Harnett County

Permit Number: EHFL2301-0002

Description: **Rudino's Pizza and Grinders**

SENT DATE	RETURNED DATE	DUE DATE	TYPE	CONTACT	STATUS	REMARKS
Review Group: ALL						
1/17/2023	1/18/2023	1/31/2023	FIRE MARSHAL	Leslie Jackson	DISAPPROVED	See Notes

**FLOOR PLAN - RETAIL BUILDING**  
SCALE: 1/8" = 1'-0"  
TRUE NORTH

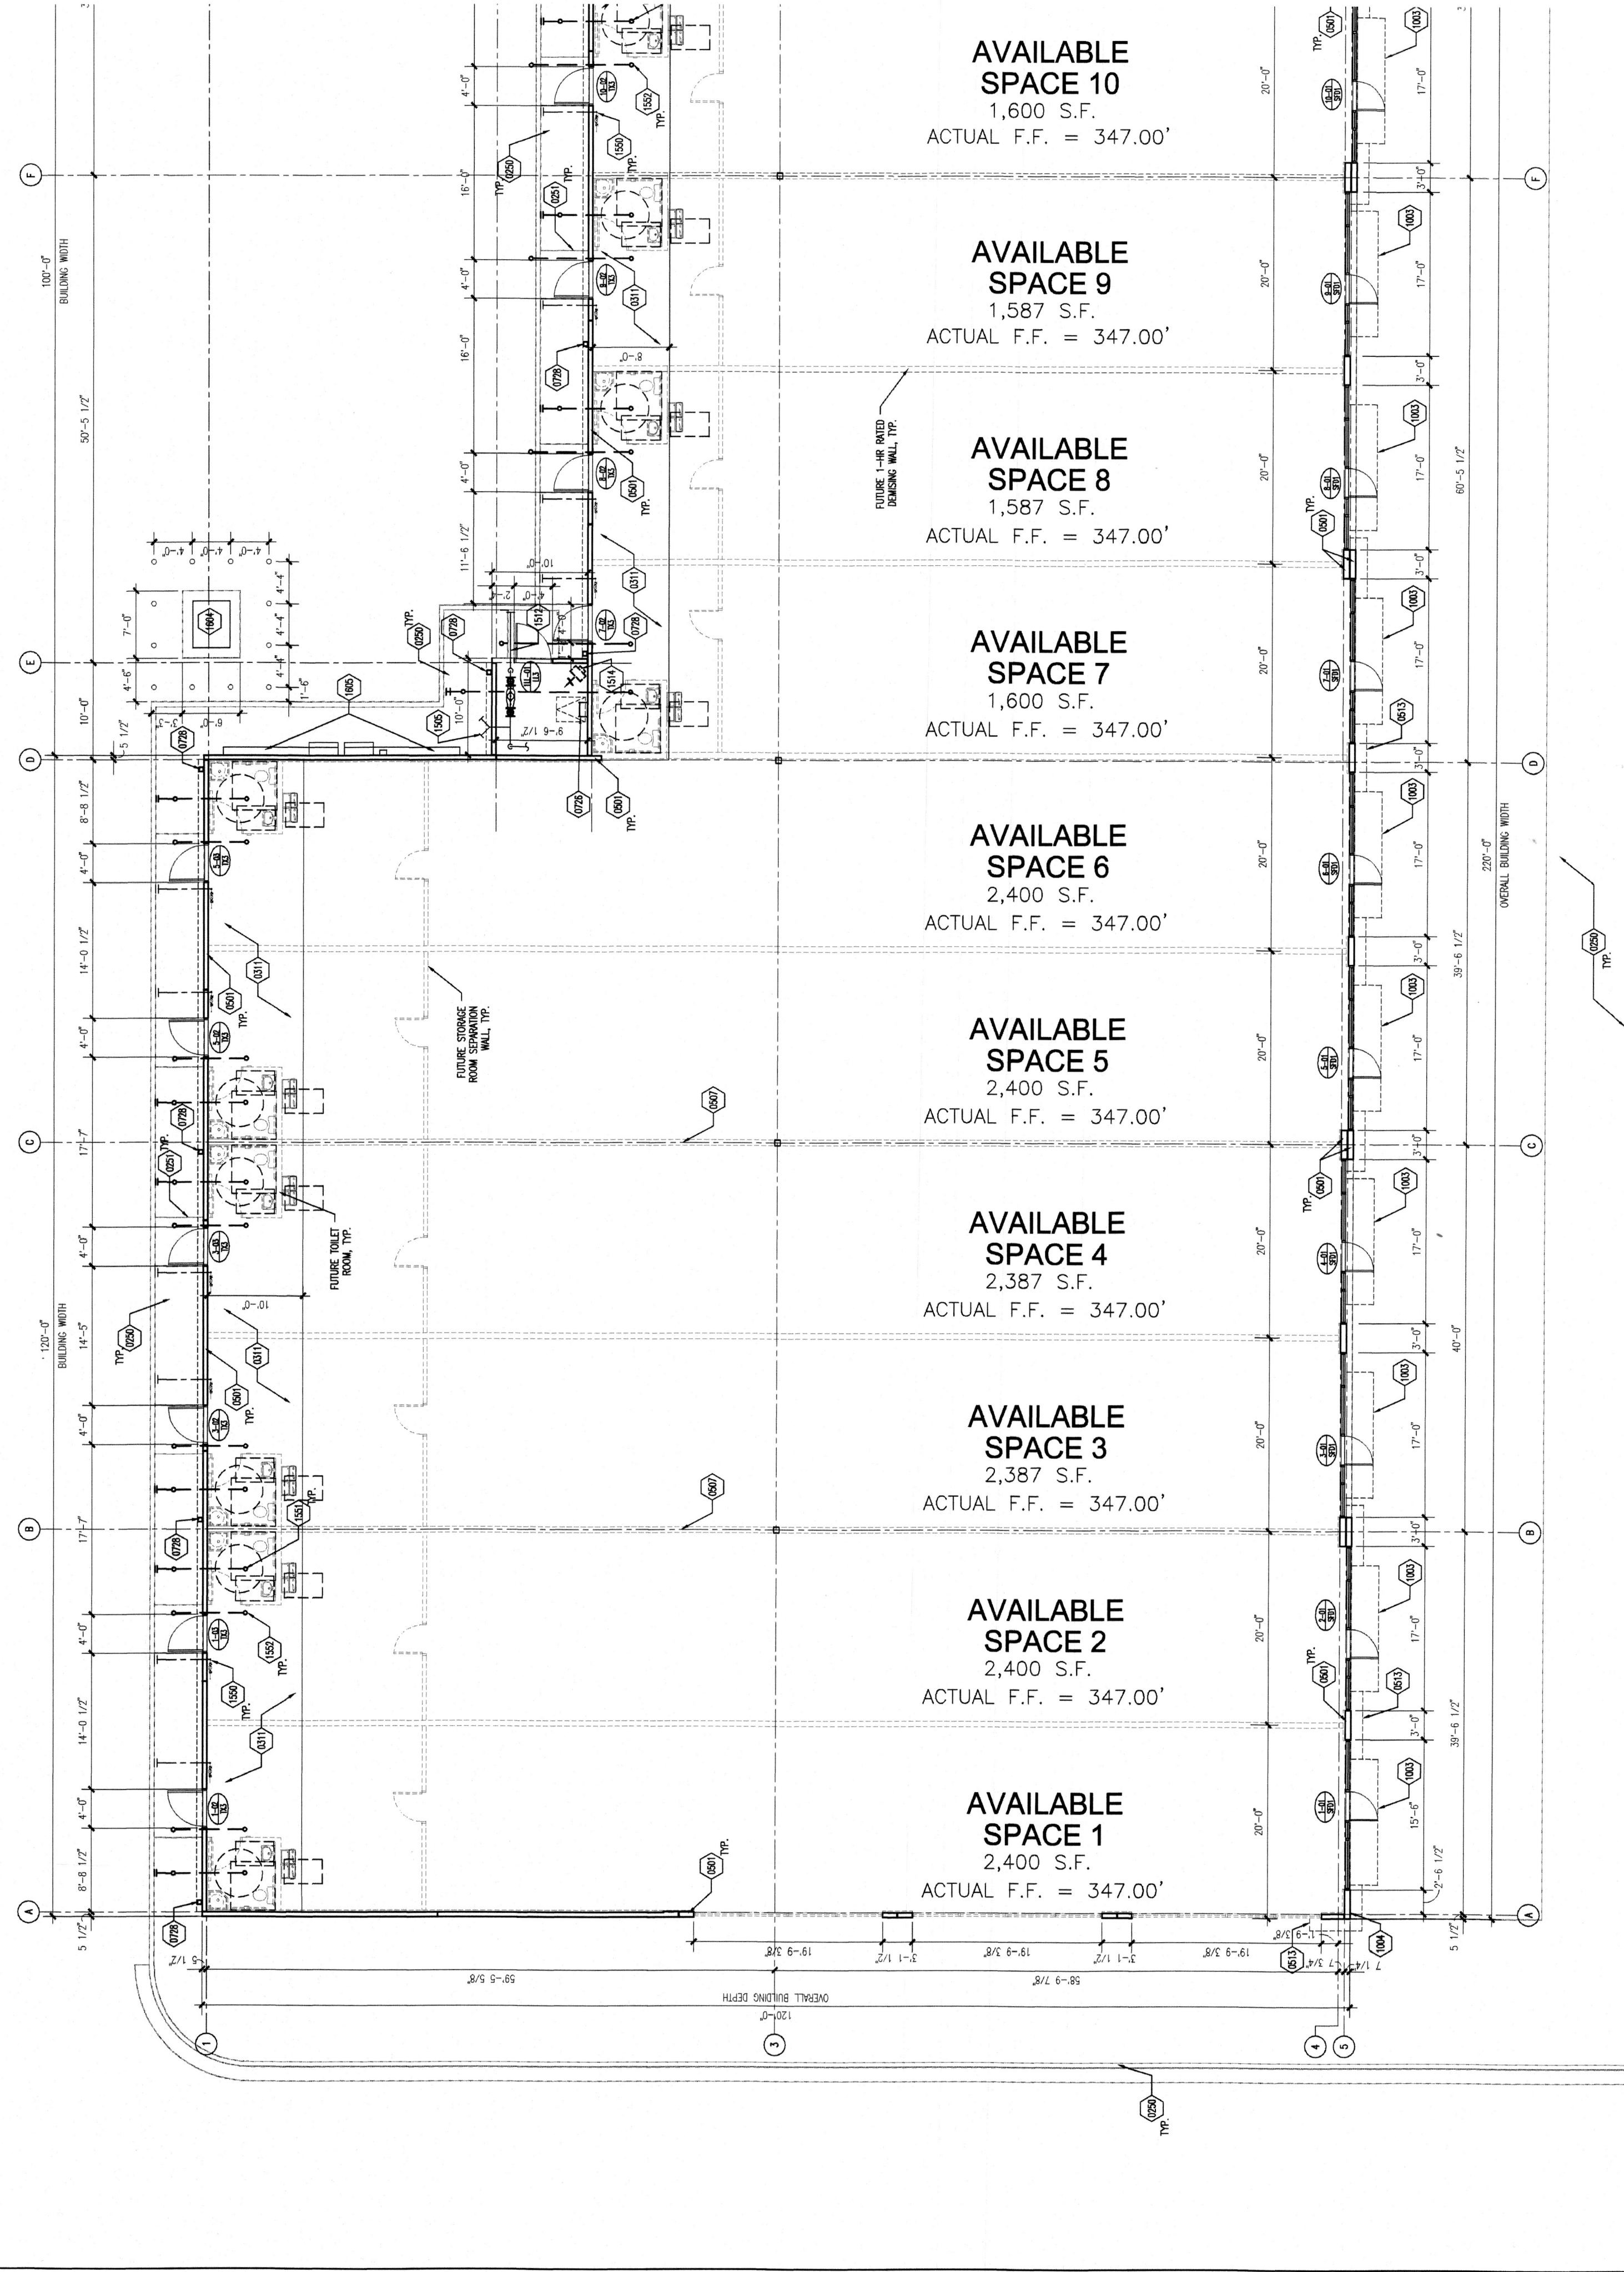
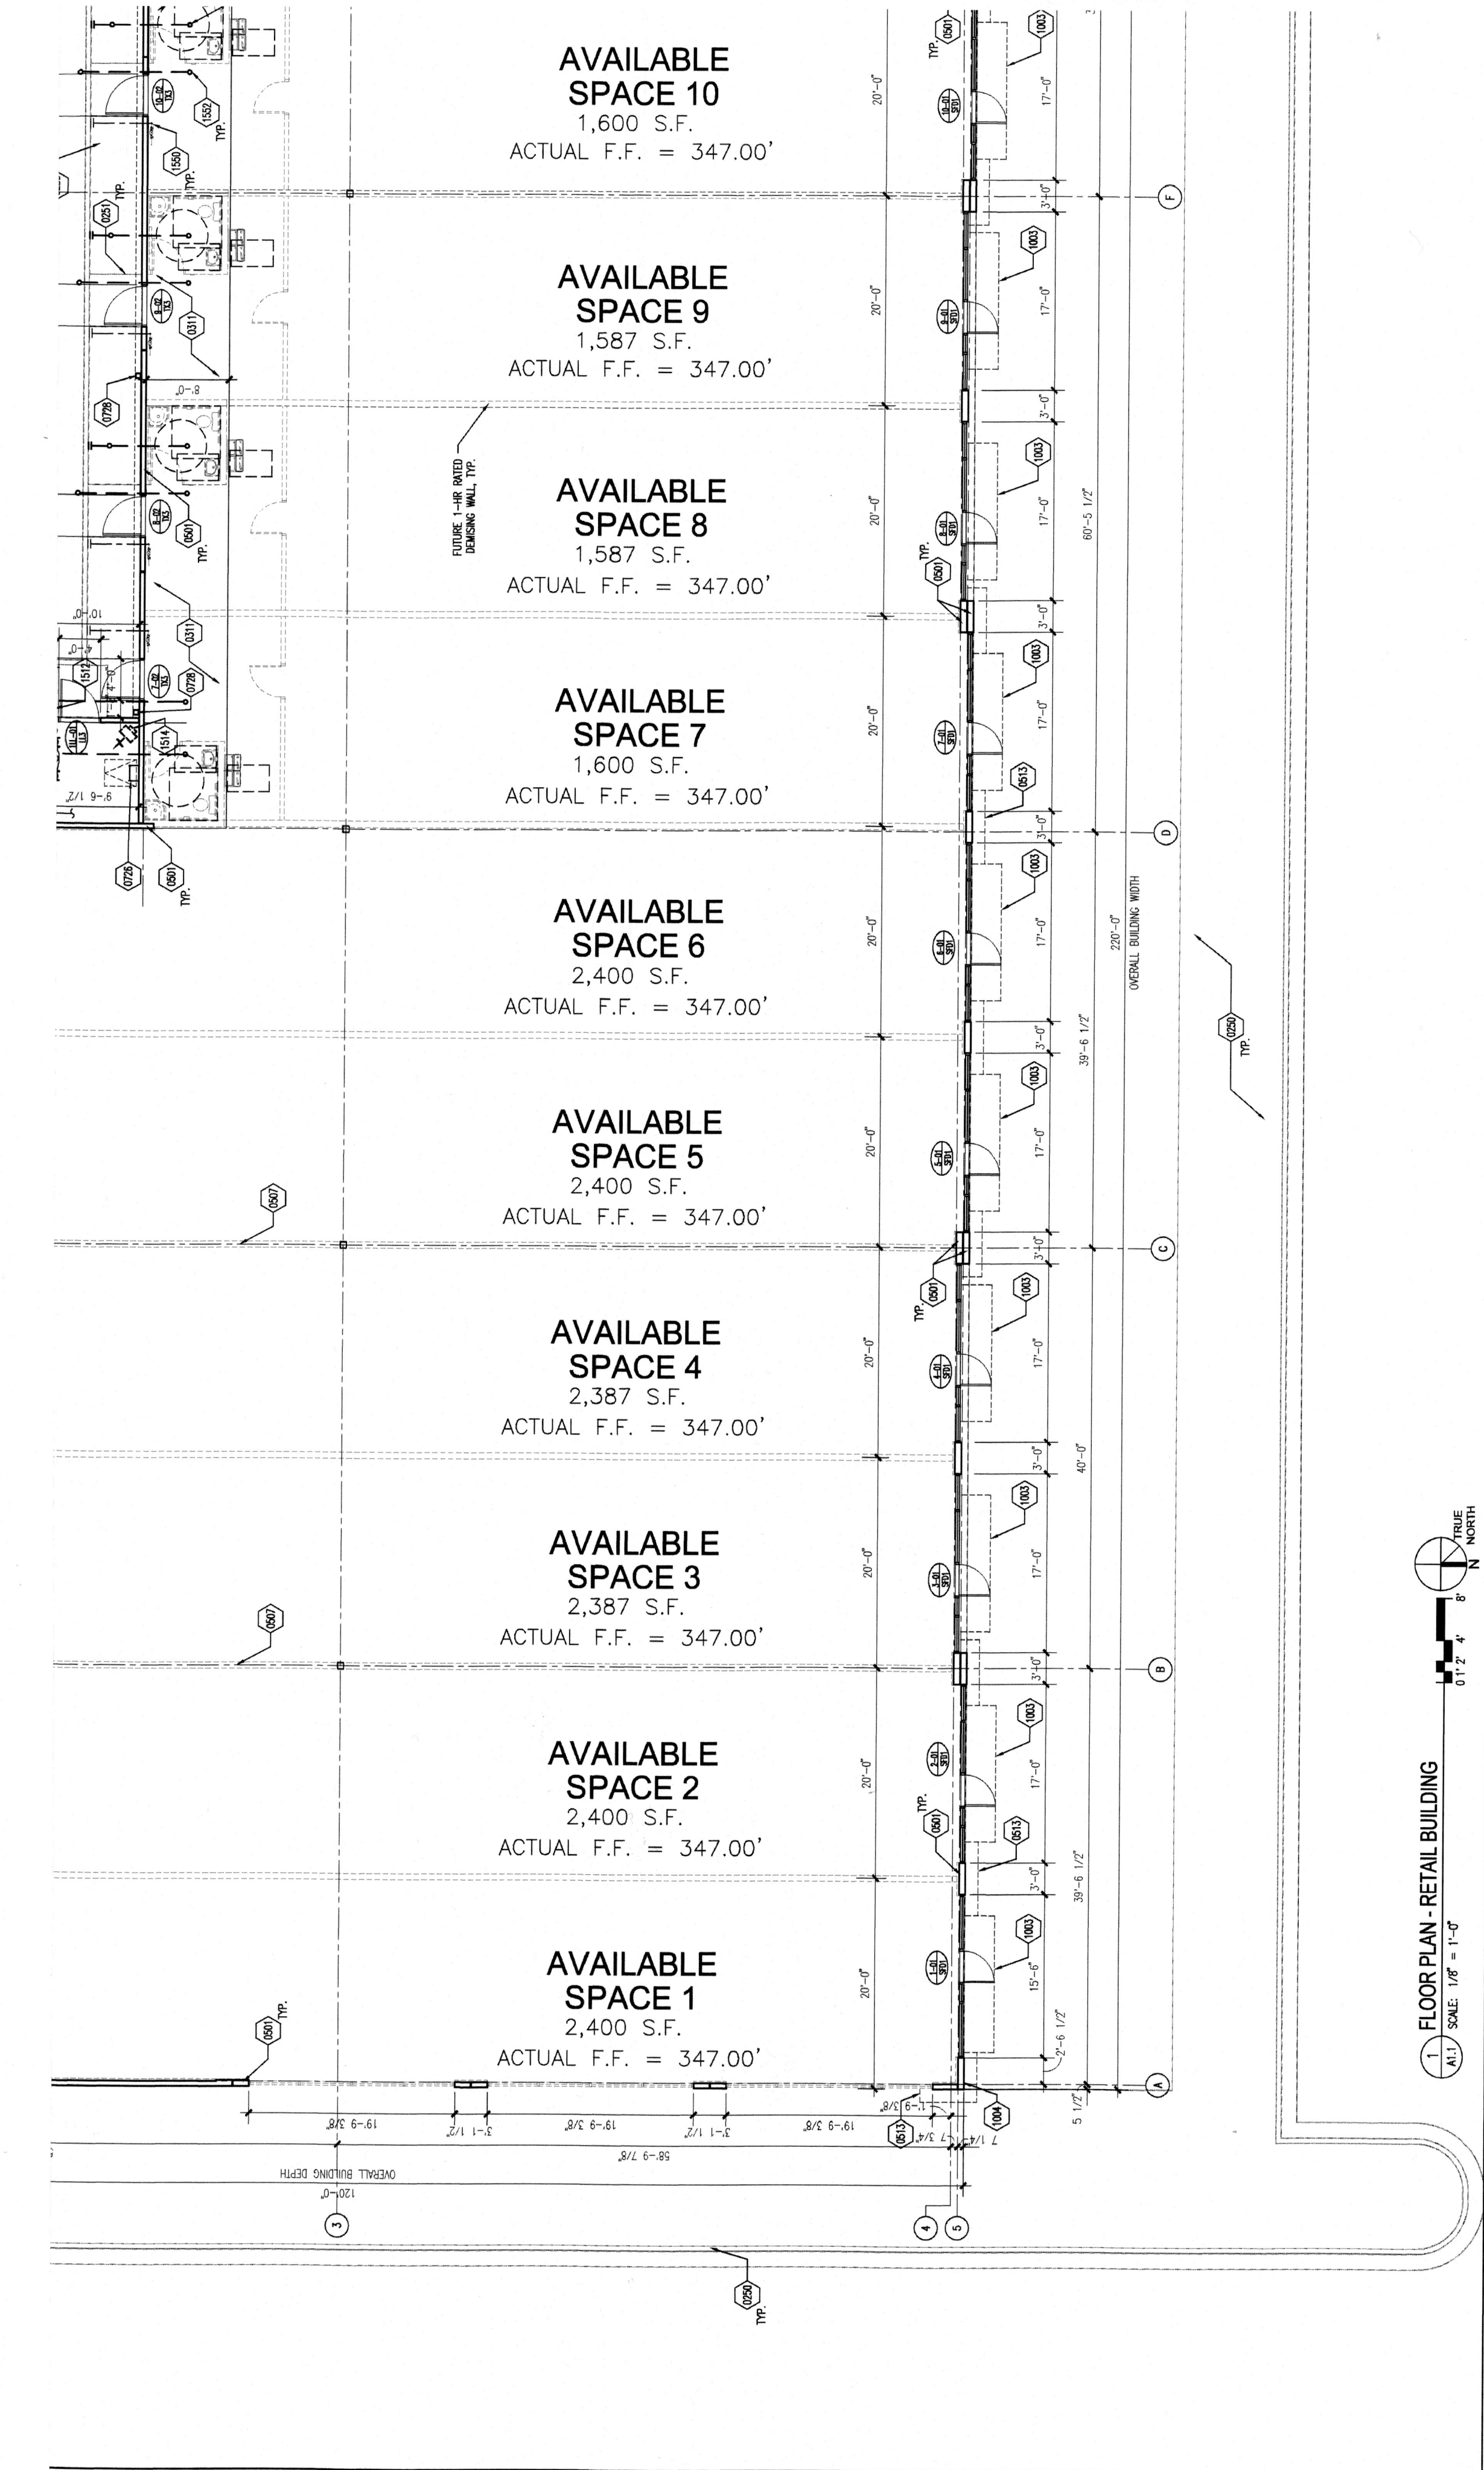
Building - Need to show a life safety plan, occupancy load

Patio
14 x 90
06

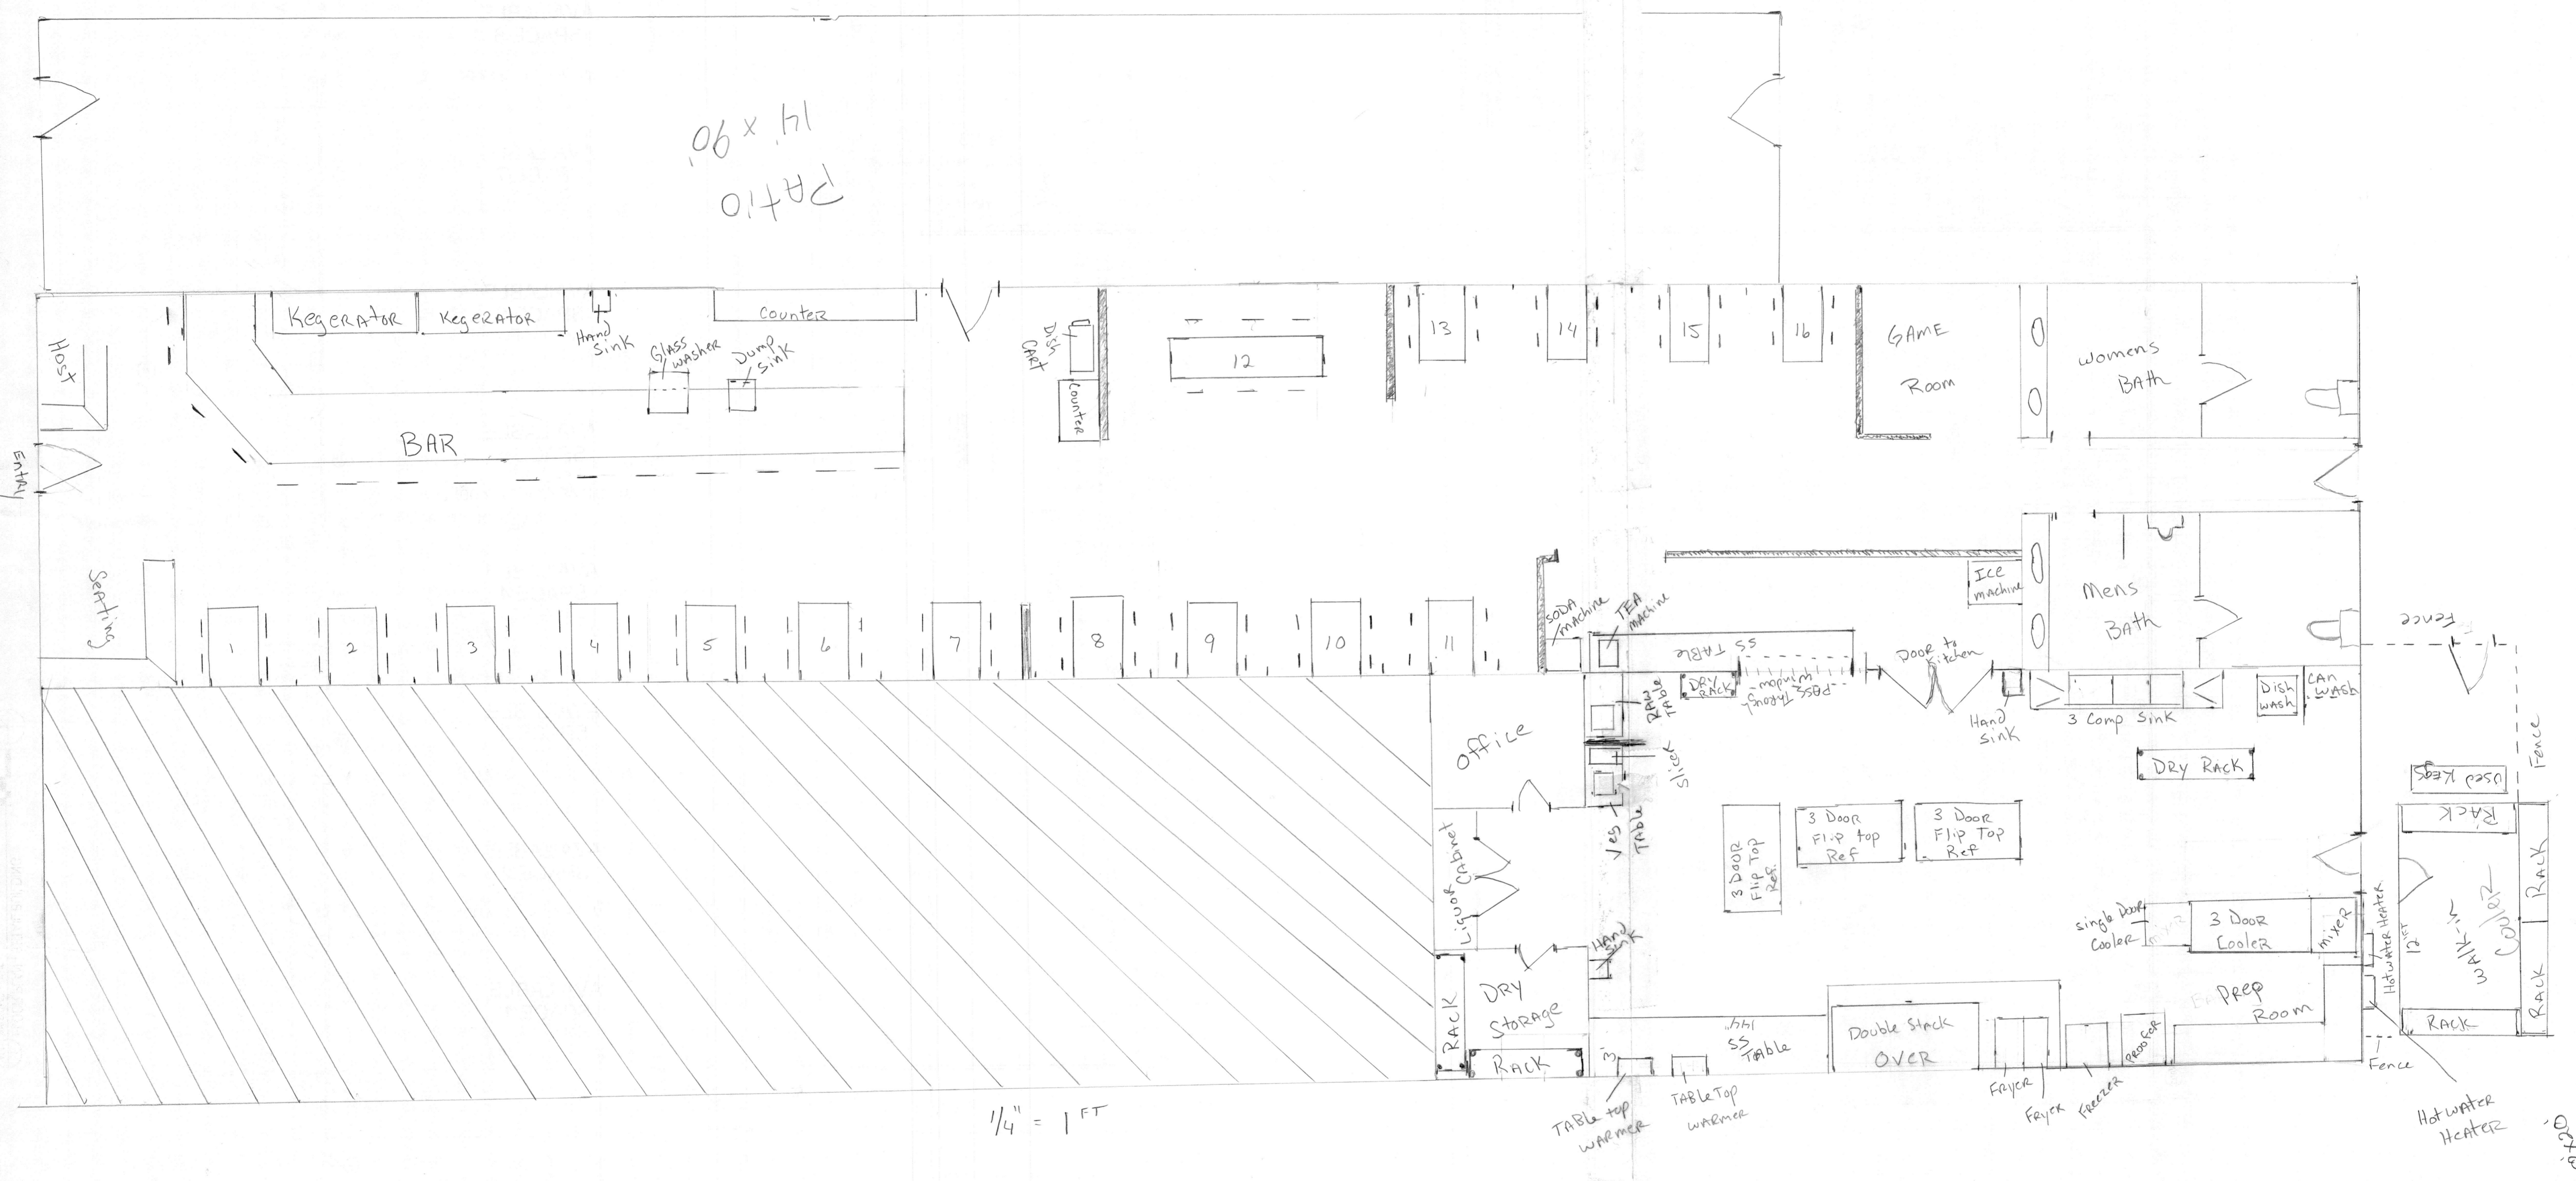
Patio - what size is patio, will it have gate and rails. will it be enclosed
